**Consultation Response from KC,
Highways Development Management****2025/92634 274, Cumberworth Lane, Denby Dale, Huddersfield, HD8 8QS****Demolition of existing dwelling, garage and ancillary outbuildings and erection of two dwellings with associated works****Date Responded: 20/11/2025****Responding Officer: Ryan Kinder****Responding Ref: K17-12/45**

2025/92634 274 Cumberworth Lane, Denby Dale.

RECOMMENDATION: No objections subject to conditions.**Development Overview:**

Scale (at A1)	Date
AS SHOWN	JAN' 2025
Drg. no.	Rev.
290-25-PL01	E

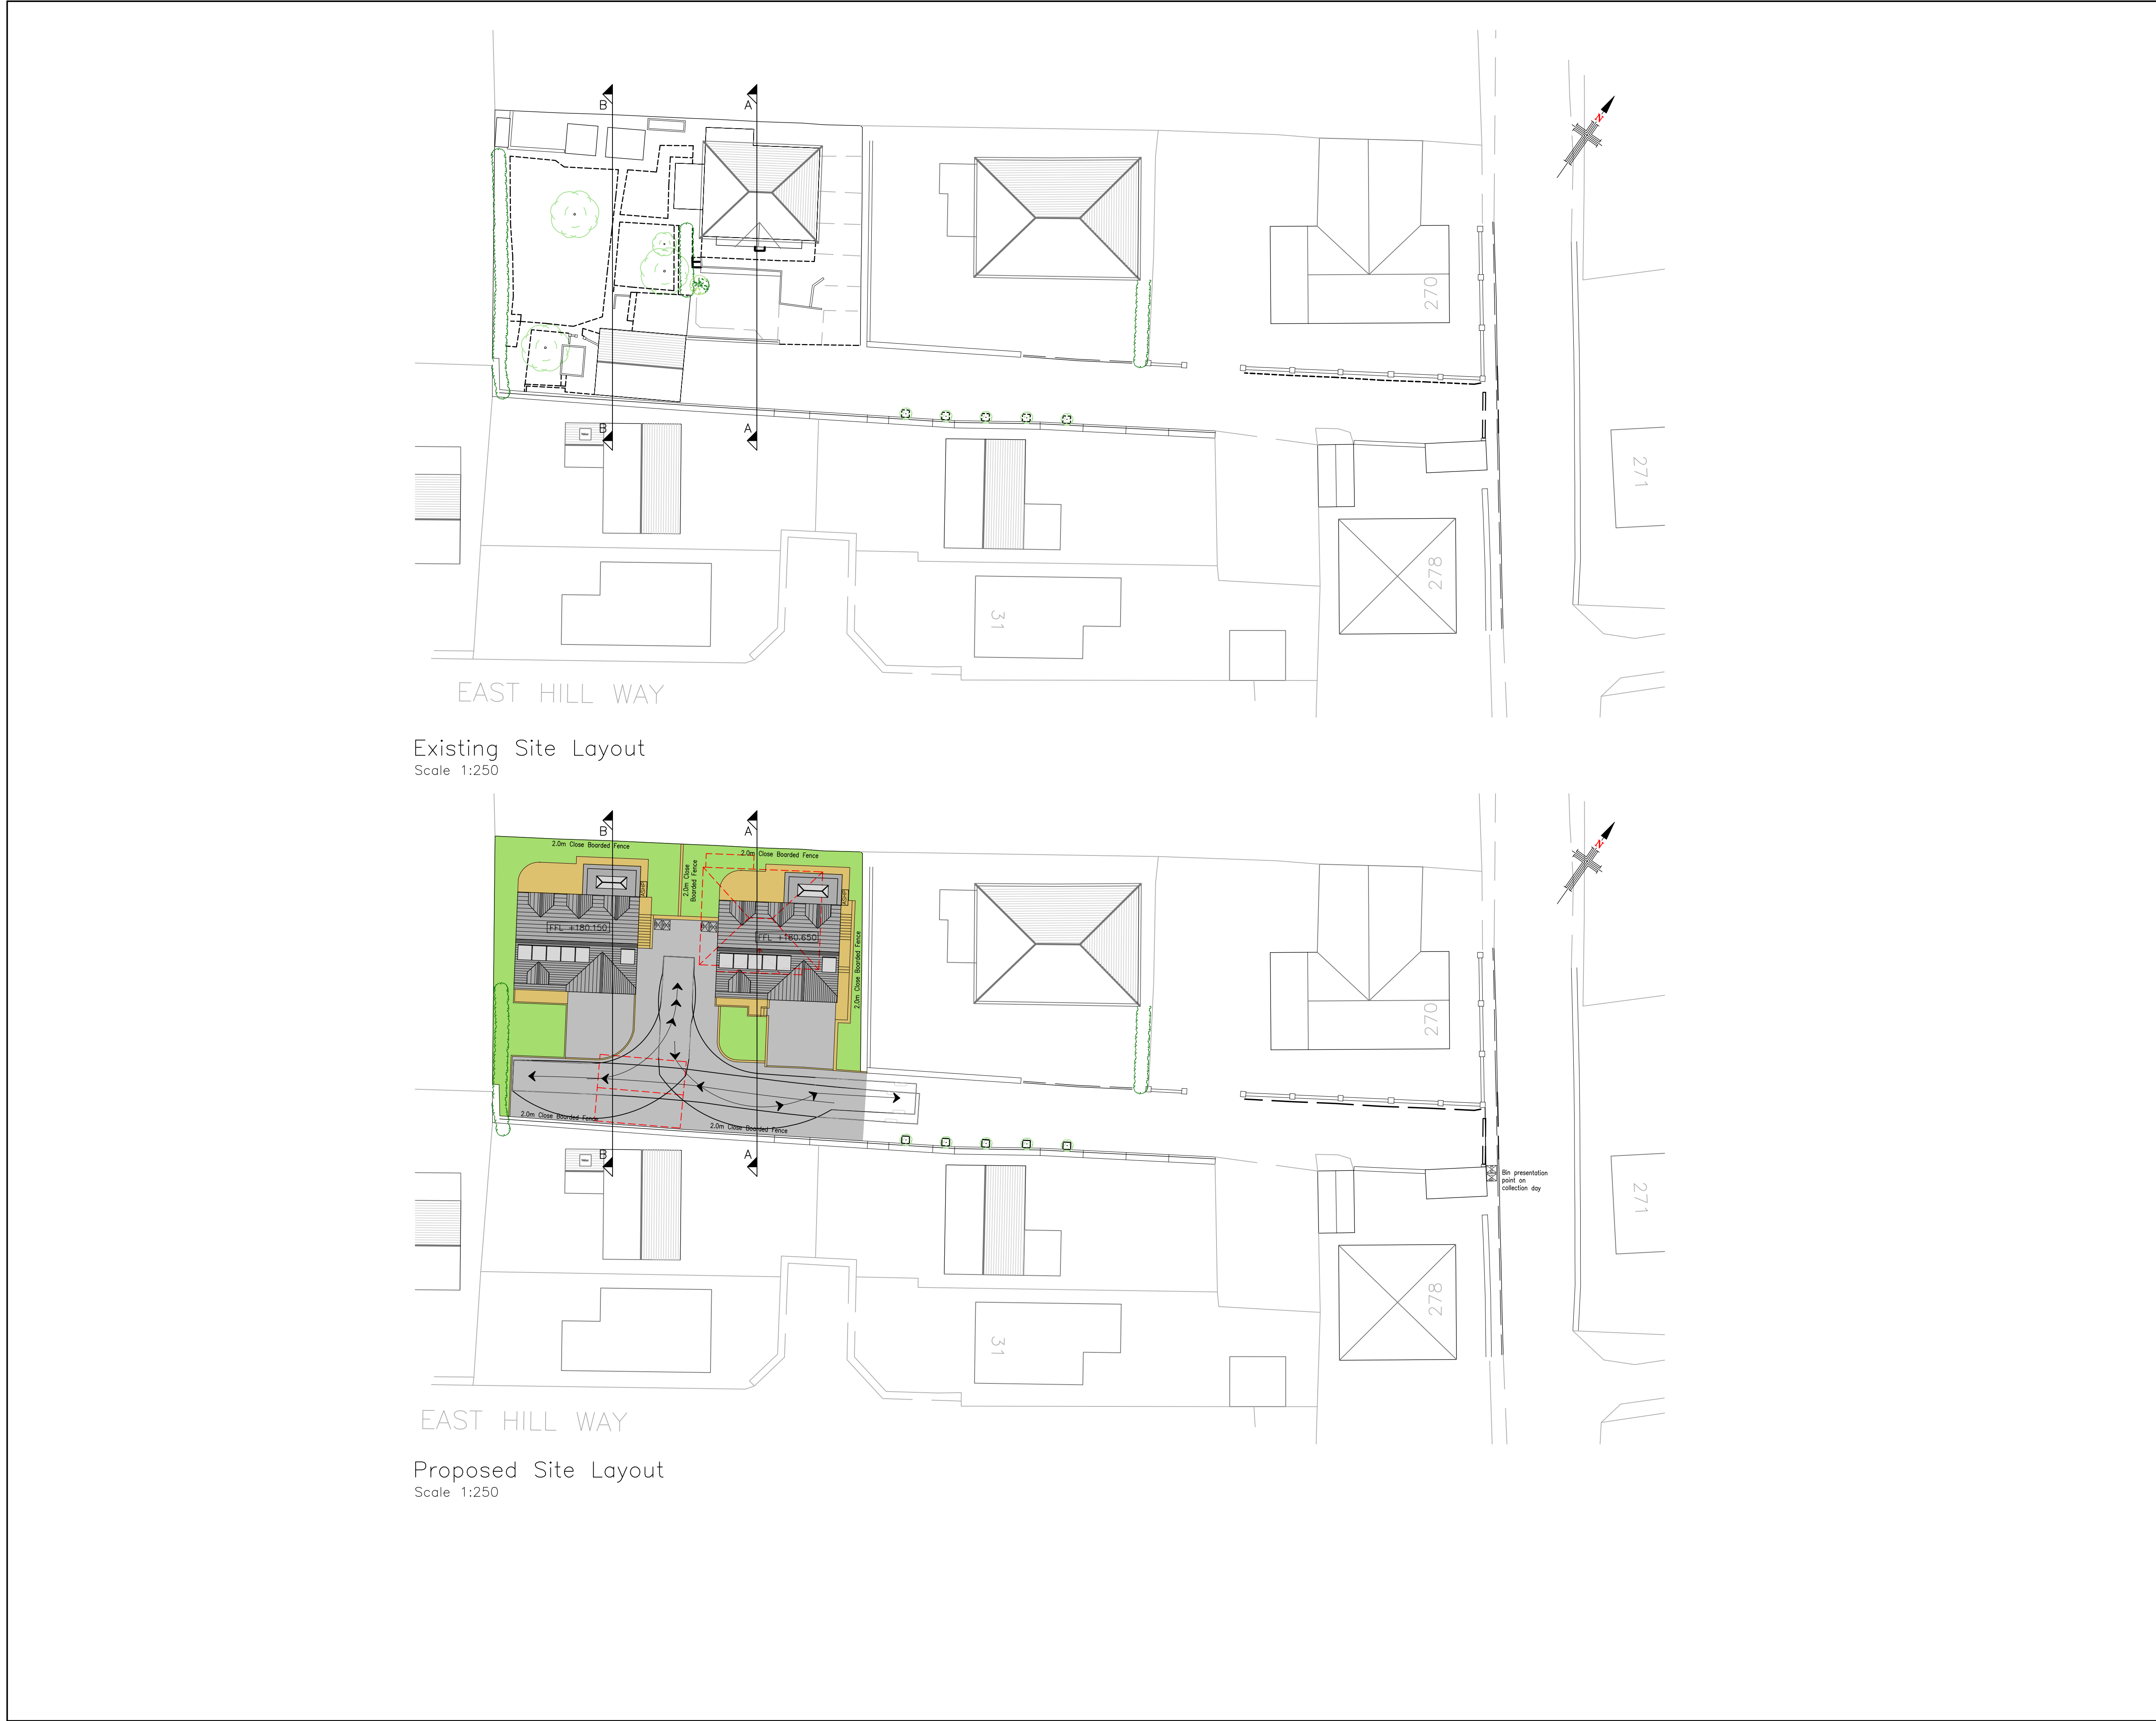
It is proposed to access the site via an existing opening onto Cumberworth Lane, whilst its acknowledged the visibility is somewhat restricted onto Cumberworth Lane, the access is well established with no record of accidents associated with existing situation, in addition there will be a provision of a turning head at the end of the development which will be of sufficient size to accommodate a delivery vehicle/fire tender. Given the betterment of this arrangement enabling vehicles to access/egress the site in forward gear, on balance is considered acceptable from a highways perspective.

The proposed development will have parking provision for up to 4 vehicles per dwelling, this is over and above the requirements in line with the Councils Parking guidance and considered sufficient.

Each dwelling will have a suitable bin storage point, bins will be collected via the indicated bin collection area indicated on the submitted plans.

Before any dwelling is occupied turning facilities shall be provided in accordance with the details shown on drawing no 290-25-PL01-E. The turning facilities shall thereafter be made available for use at all times by vehicles and shall be kept free from obstruction to such use.
